# CITY OF PORTLAND

# BUILDING PERMIT

Job ID: 2012-05-3901-ALTR

has permission to install a ramp for ADA access (Single Family Residence).  
provided that the person or persons, firm or corporation accepting this permit shall comply with all of the provisions of the Statues of Maine and of the Ordinances of the City of Portland regulating the construction, maintenance and use of the buildings and structures, and of the application on file in the department.

805 Brighton Ave PTLD, MAINE

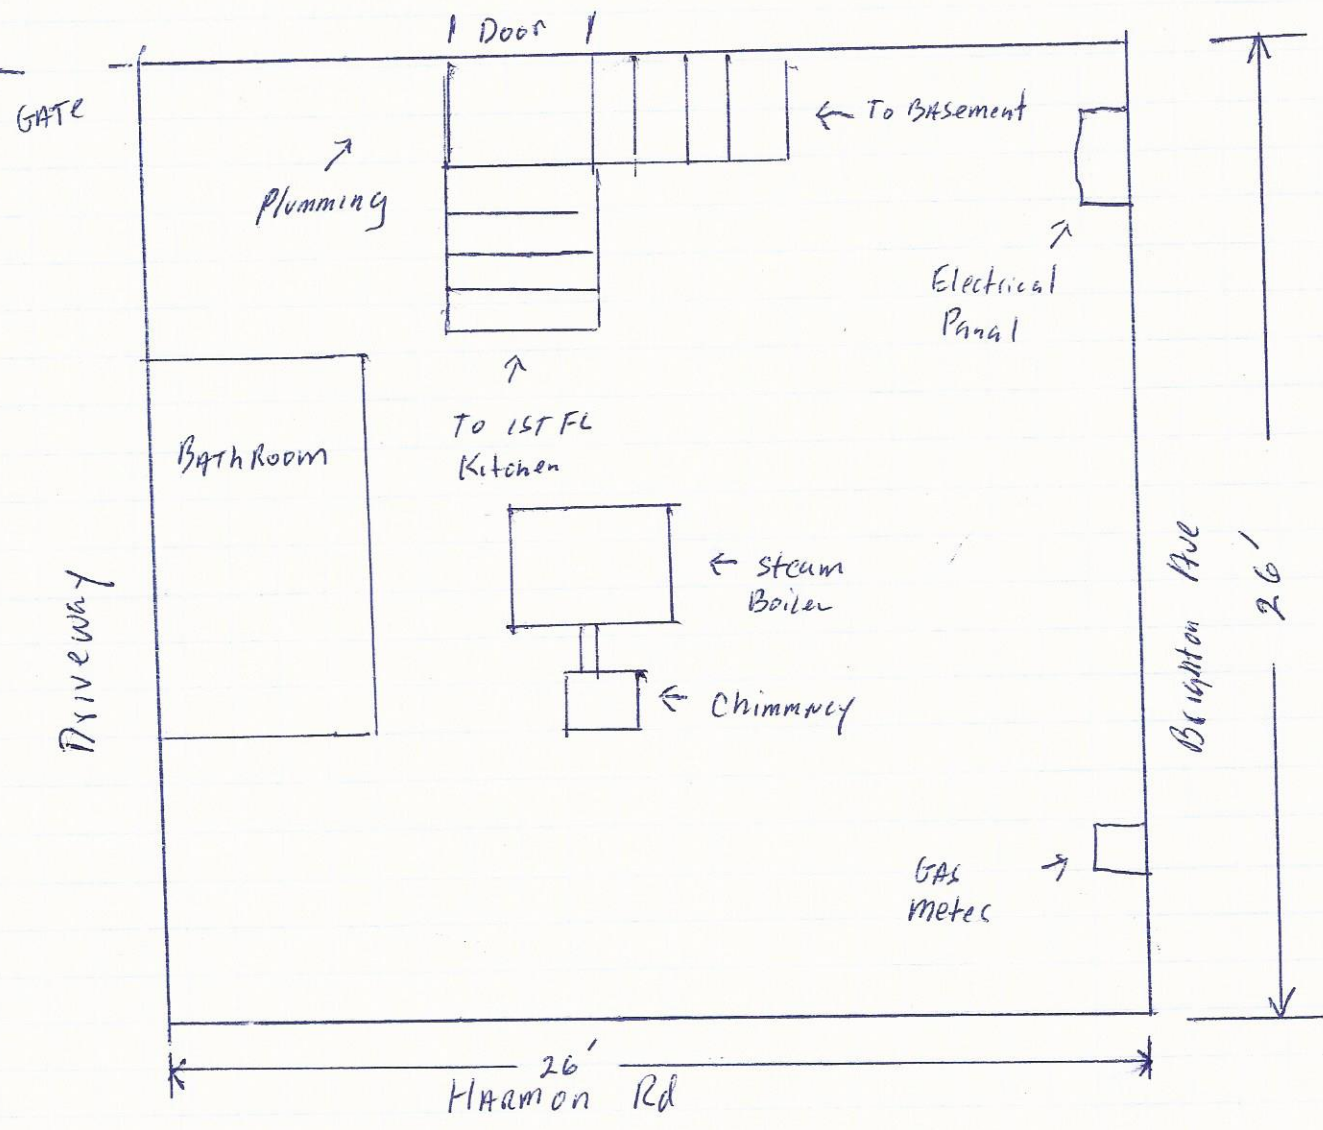
\* front setback - 25' - 19' from front prop. line

\* side yard / side street - 20' min - 6' given

5-11-12 Left vcm for contractor, Olin Irish. Ramp does not meet 25' front setback or 20' side setback. Am moving permit forward in the review process but owner needs to apply for a disability appeal within 30 days. -amachado

1. This permit is being approved on the basis of plans submitted. Any deviations shall require a separate approval before starting that work.
2. This property shall remain a single family dwelling. Any change of use shall require a separate permit application for review and approval.
3. The proposed ramp does not meet the required front and side setbacks. This permit is being issued with the condition that the applicant has thirty days after the permit is issued to apply for a Disability Variance.

You applied for a permit to build a ramp to make your house at 805 Brighton Avenue accessible for a wheel chair. 805 Brighton Avenue is located in the R-3 residential zone. The required front yard setback (measured from the inside edge of the sidewalk) is twenty-five (25) feet [section 14-90(d)(1)]. The submitted plot plan showed the setback to the proposed ramp as about nineteen (19) feet. The required side setback on a side street is twenty (20) feet [section 14-90(d)(4)]. The submitted plot plan gave the side setback to the proposed ramp as six (6) feet. Since the ramp has to be installed immediately, the permit has been issued to build it, but you need to apply for a disability variance within thirty days of the permit being issued, since the ramp does not meet the required front and side setbacks.
